ATTACHMENT 3

40 queries relevant to water use
(Field Development Planning)

1-5. RIGHTS OF GROUNDWATER USERS

5-37. RISKS TO SIGNIFICANT SPECIES IN SPRINGS AND WATER COURSES

Figure 2: West-east modelled cross section. Source: Adapted from Figure 51 from (Jacobs (Australia), 2020, pp. 5-143)

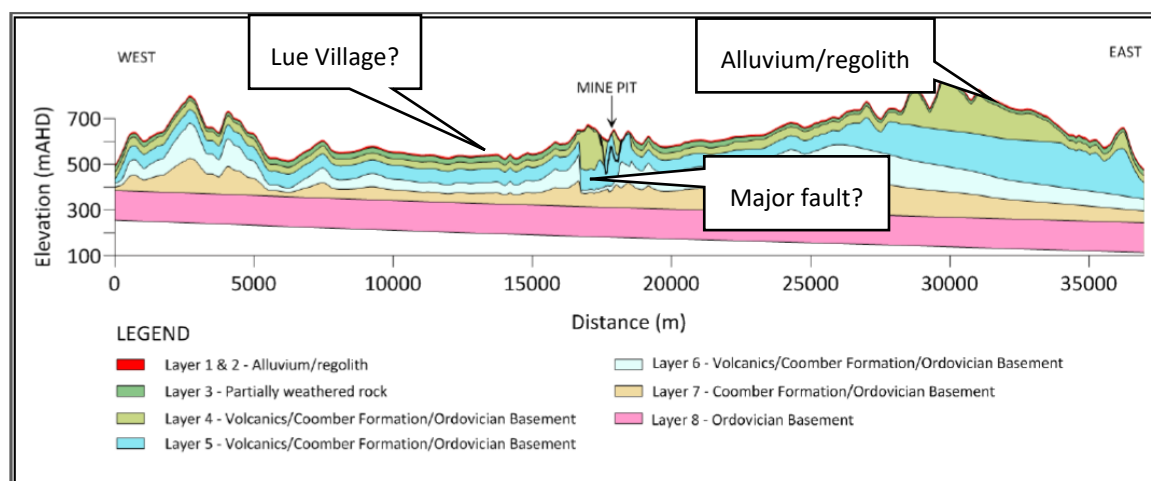
When this information is compared to the EIS interpretation (Figure 2) and while faulting can be inferred, the mapped outcrop of Late Ordovician-Early Silurian age Ocd (Coomber Formation) near Lue village north west of GW021442 is not presented in the EIS. Suggested cross section transects are shown in Figure 1.

This discrepancy (a lack of Ocd outcrop on Figure 2) highlights an area for future focus to adequately represent the hydrogeology in the alluvium near Lawsons Creek proximal to Lue Village bores and the associated significant species.
